Case Officer: Matthew Chadwick

Recommendation: Refused

Applicant: (EE (UK) Ltd and H3G (UK) Ltd)

Proposal: Street works style base station - the installation of a 17-metre phase 8 pole with wrap around cabinet built around the base, 3 no. new equipment cabinets and ancillary development thereto.

Title: 215 PROPOSED SITE PLAN

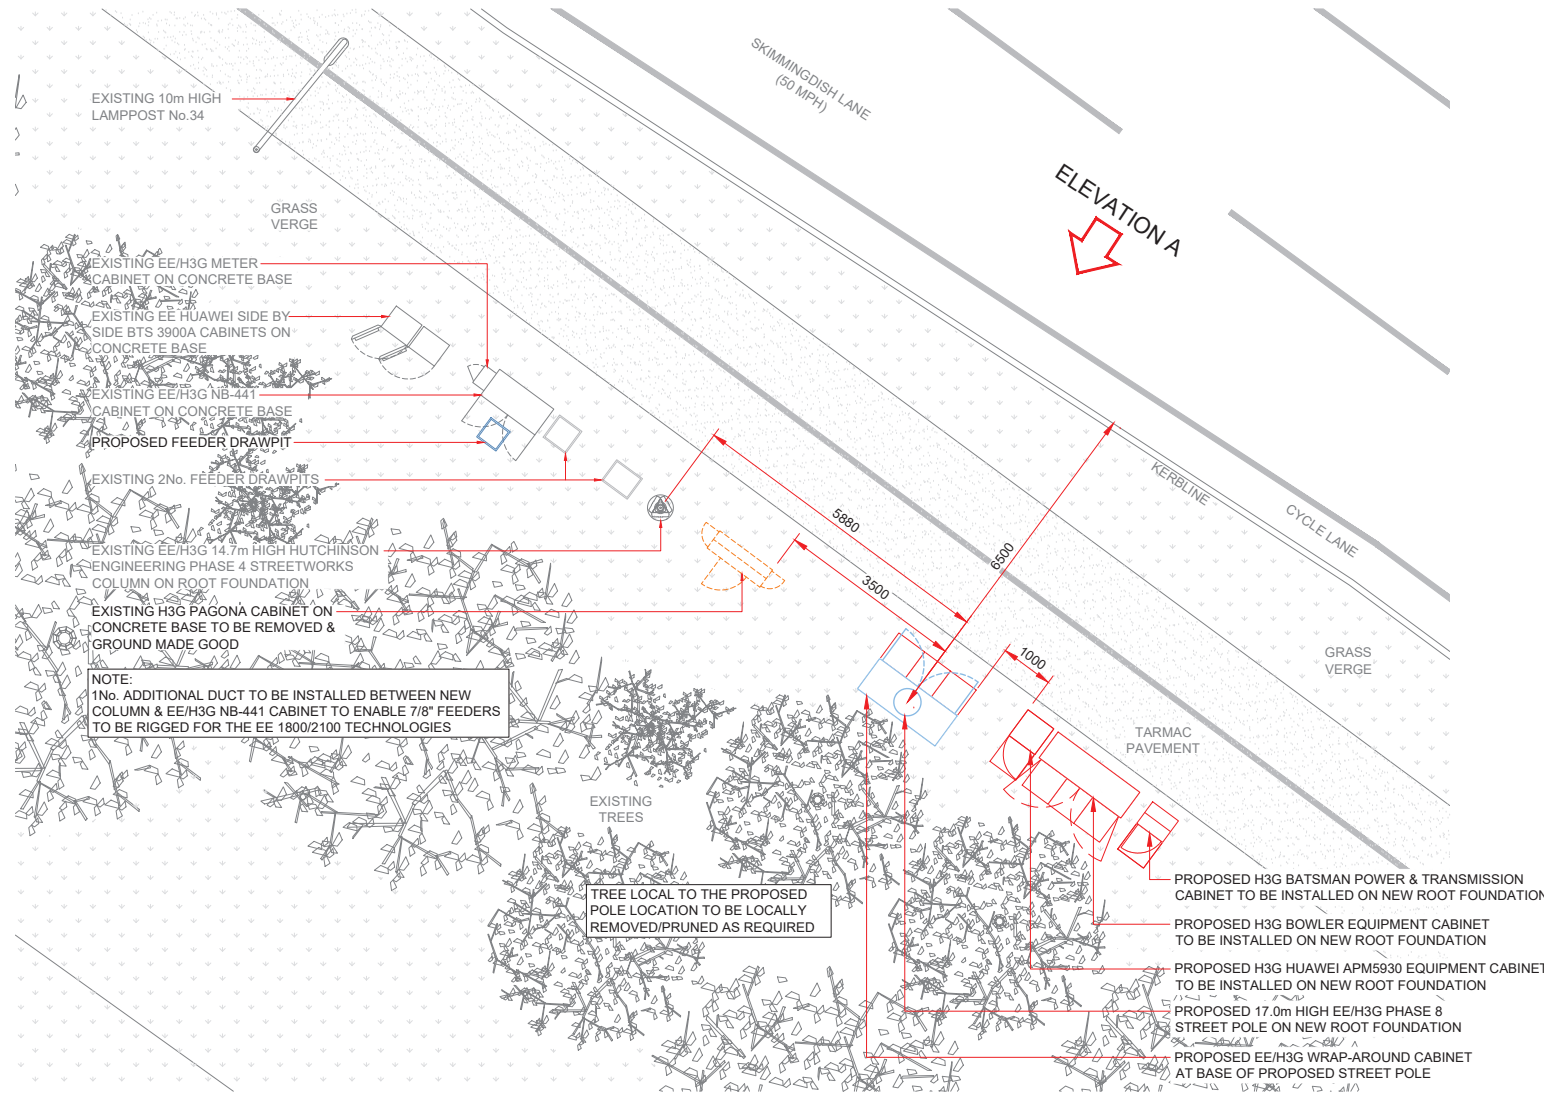
- 2.1. The proposal consists of the upgrading of an existing mast site. An existing 14.7m tall 4G pole is to be retained, with a new 17m high 5G mast to be erected directly adjacent to the existing pole. A new 5G pole is proposed on the basis that Central Government considers digital communications to be a critical national infrastructure. The applicant states that the existing 4G pole is to be retained in order to maintain current services, to benefit users of that network and for EE to dedicate the 4G coverage for the use by emergency services.

- 8.8. The proposal consists of the erection of a new mast with ancillary equipment cabinets, to be shared by two operators (EE and Three). The land is highway verge adjacent to a classified road. The site is not of any particular landscape sensitivity, but the mast would be visually prominent as viewed from users of Skimmingdish Lane.

- 8.9. The design and dimensions of the pole are restricted in order to meet the requirements to provide 5G coverage. The height of the pole is 20m with the

antenna being positioned so it does not increase the height of the pole. The mast would be relatively slim line and coloured grey and although taller would not look too dissimilar to the lampposts and existing mast which are sited along this section of highway. The cabinet would be painted green and would blend in with the existing vegetation.

- 8.11. The addition of a second, taller mast in this location would result in proliferation and is not considered ideal in visual terms and would result in visual harm.

- 8.15. The aviation impact assessment shows that the proposed mast would be within the obstacle-free take-off climb surface for Runway 24 from the Bicester Motion site, as set out in CAP 168, The Licensing of Aerodromes, a document produced by the Civil Aviation Authority.

- 8.16. The aviation impact assessment states that the result of the erection of this mast would be shortening the existing Runway 24 by at least 150m, and a reduction in potential useable flying area within the South Western corner of the flying area, inside the airfield perimeter track, of around 200m. The aviation impact assessment has been calculated on the basis of the mast being 16m in height (as the application stated when submitted before being corrected), so the impact on the airfield would be worse than that calculated in the aviation impact assessment.

- 8.17. As previously stated, there is an existing 14.7m mast in close proximity to the approved mast. However, it has not been demonstrated in the submission that the siting of the proposed mast would not impact the aviation operations of Bicester Motion. The proposal is thus considered unacceptable with regard to its siting.
